# CITY OF ALBUQUERQUE

RE: **Lot 3 Block 10 Unit 22, S.A.D. 228**  
**6424 Petirrojo NW**  
**Grading and Drainage Plan**  
**Engineers Stamp Date 5-10-18 (D10D003F3)**

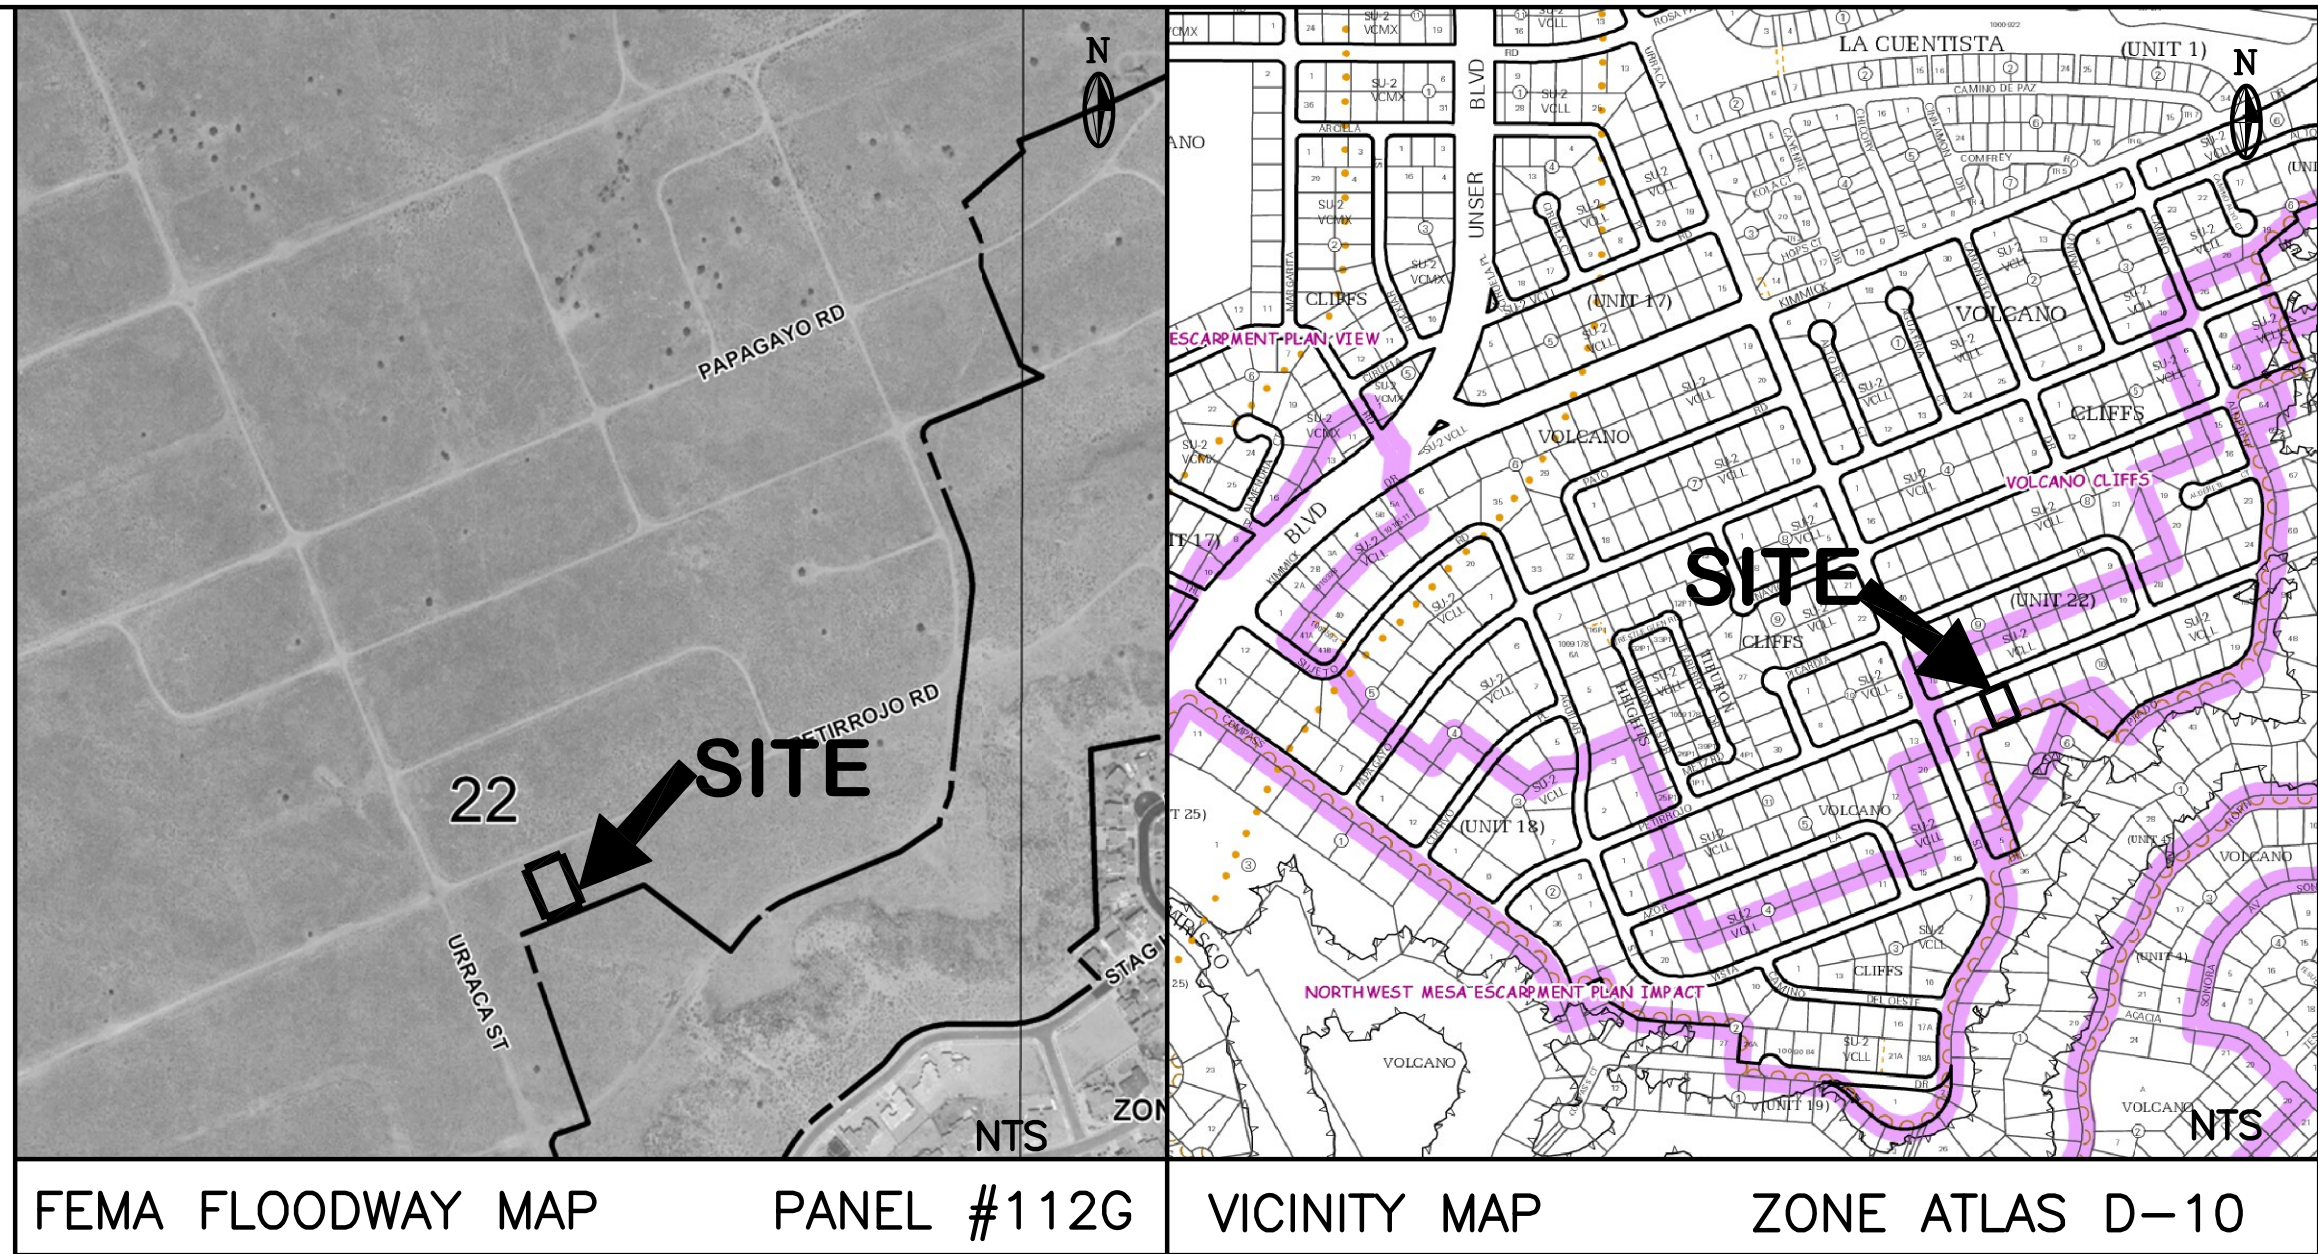
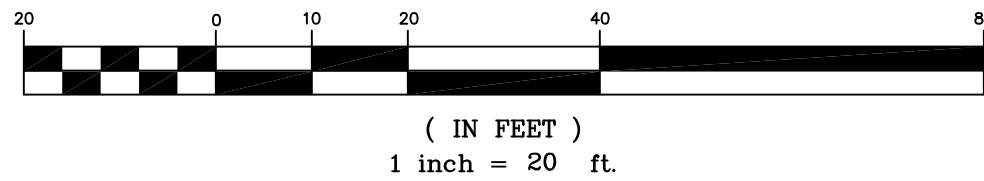
- Provide a cross section of the block walls/fence showing the location of the footing. If the footing is encroaching onto the abutting properties a letter of acceptance will be needed from the property owners for the placement of the footing.
- Provide the size of the openings and calculations for the turn blocks, to show that the openings are sufficient for the passage of the flows required.
